CITY OF PORTLAND, MAINE

PLANNING BOARD

June 12, 1997

RE: Cheverus High School, 267 Ocean Avenue

PROJECT NO. 97.117-00 DRAWING NO. SD-1
 DESIGNED BY FLC
 DRAWN BY FLC
 CHECKED BY FLC
 SCALE 1"=50'
 DATE 3/31/97

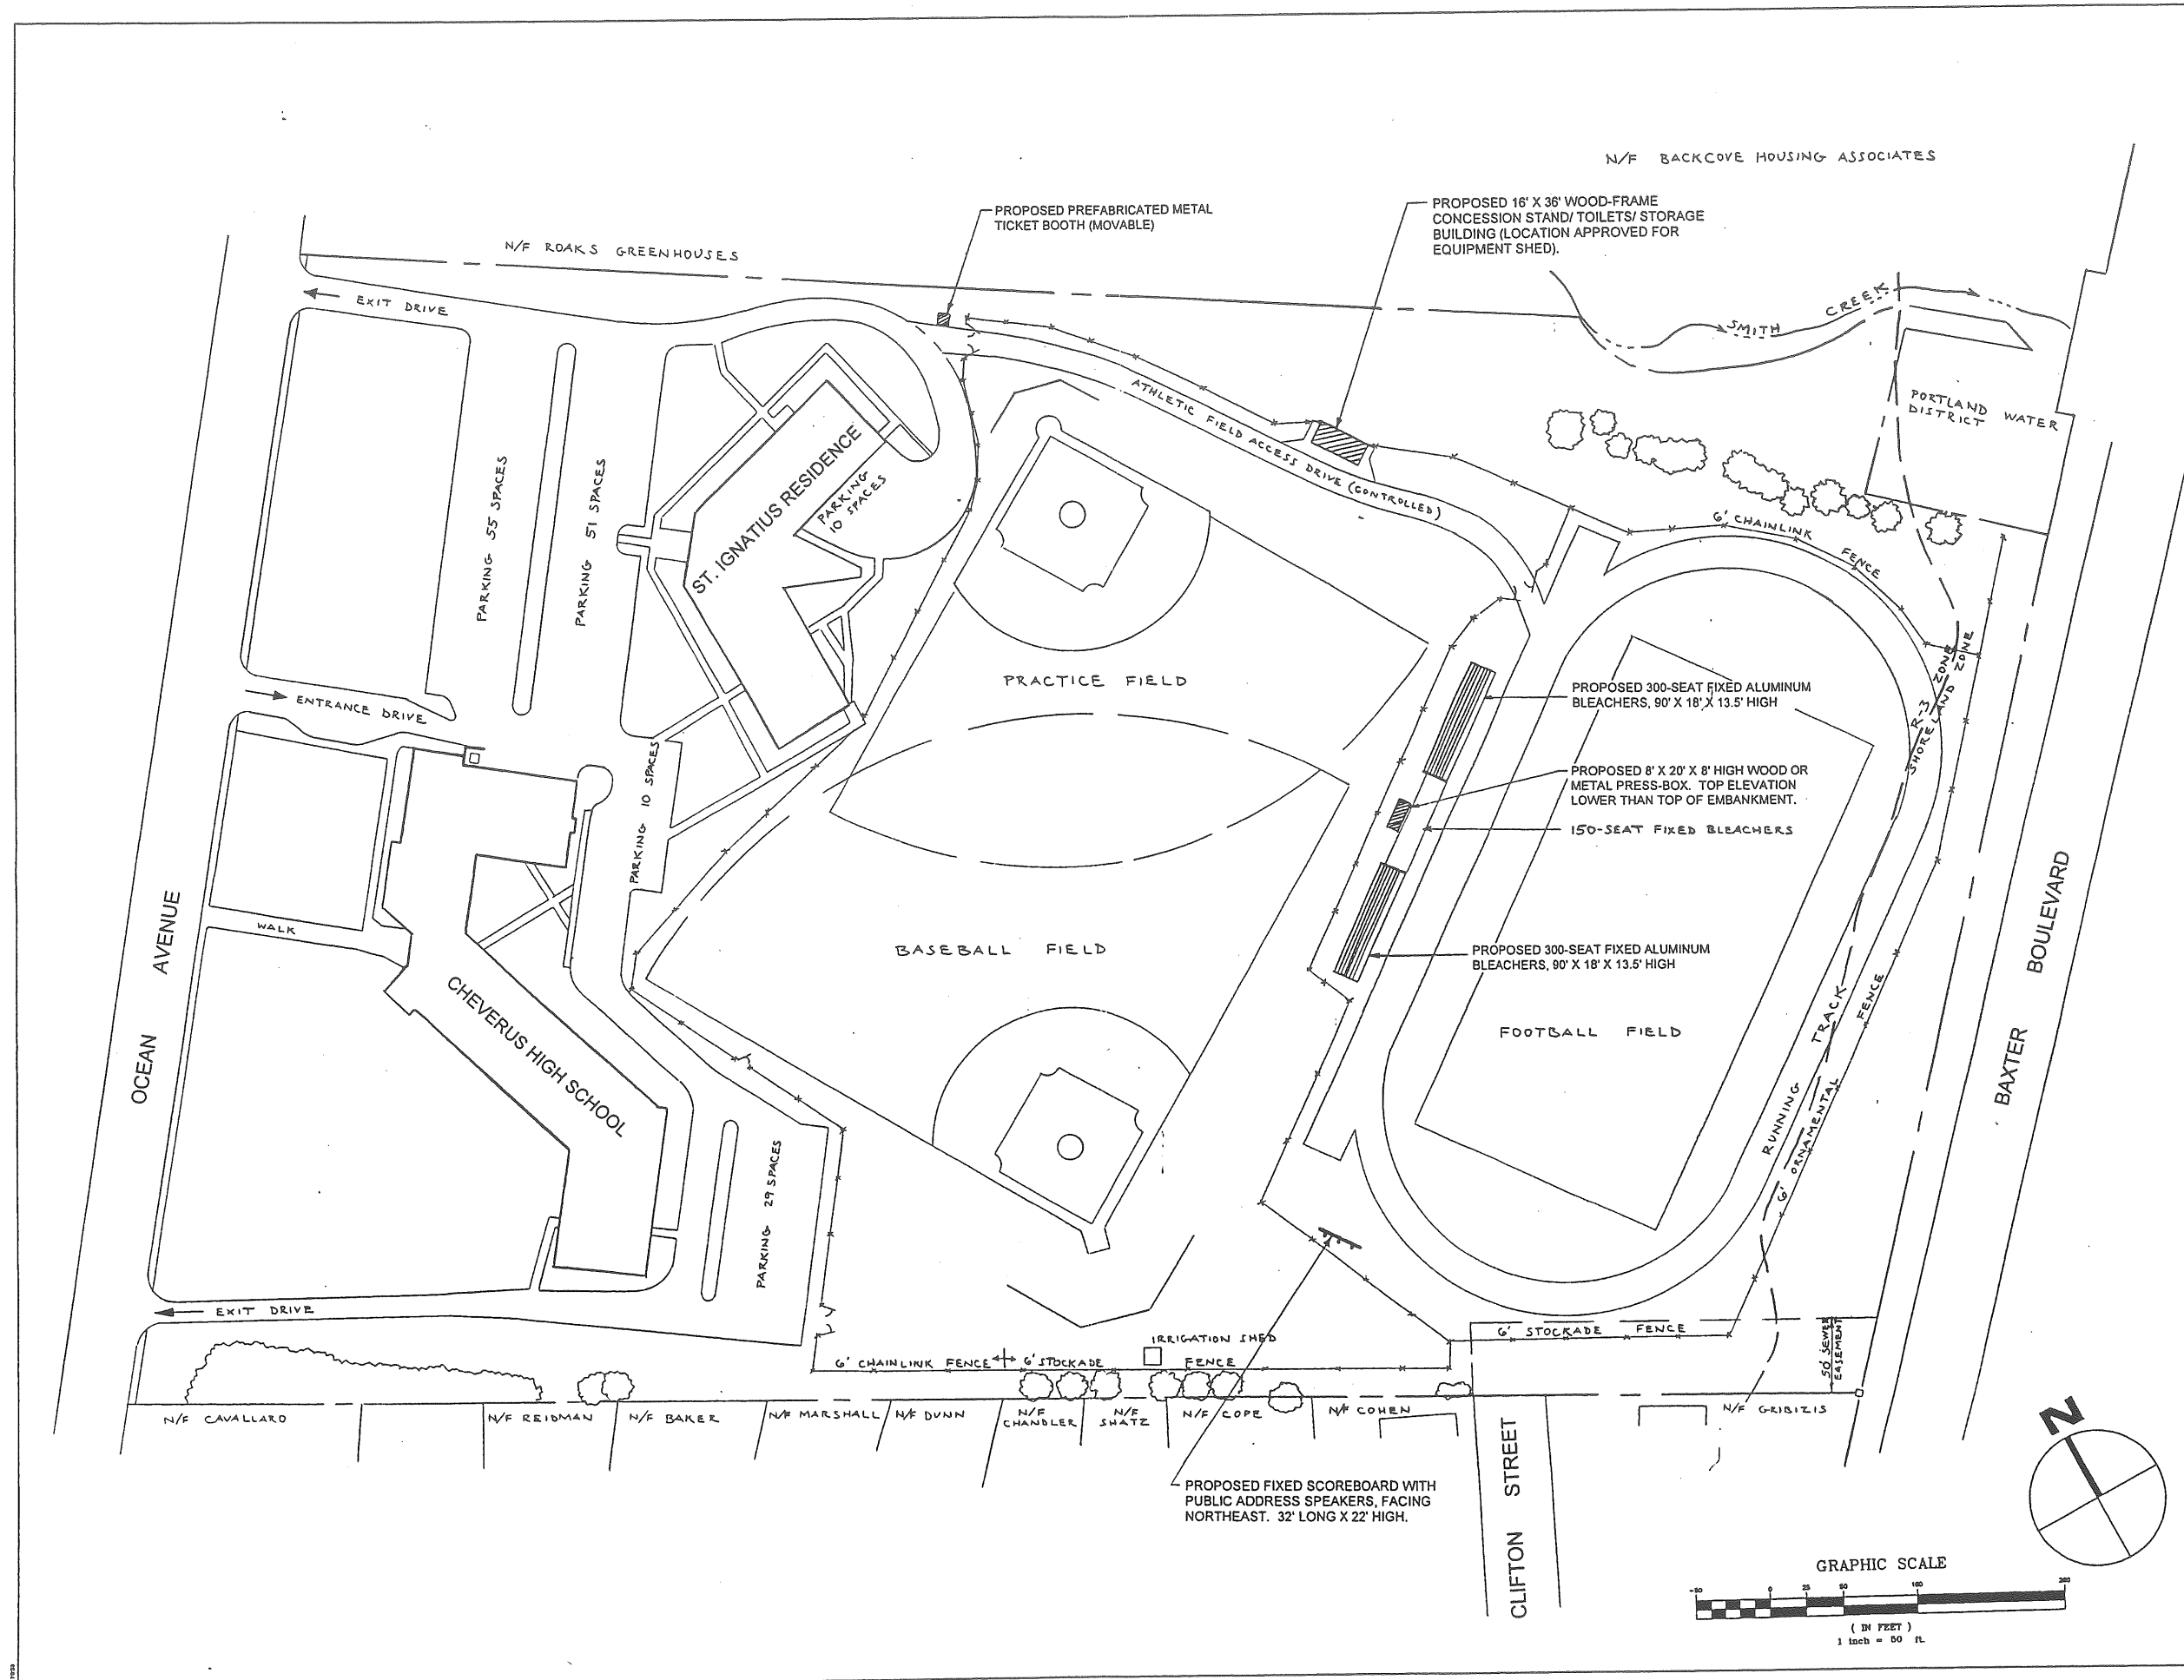
- i. That the plan be revised indicating a water line and sewer line to the concession stand/restroom for staff review and approval.
 - ii. That the site plan be revised indicating sod material to stabilize the slope area disturbed by the bleacher installation for staff review and approval.
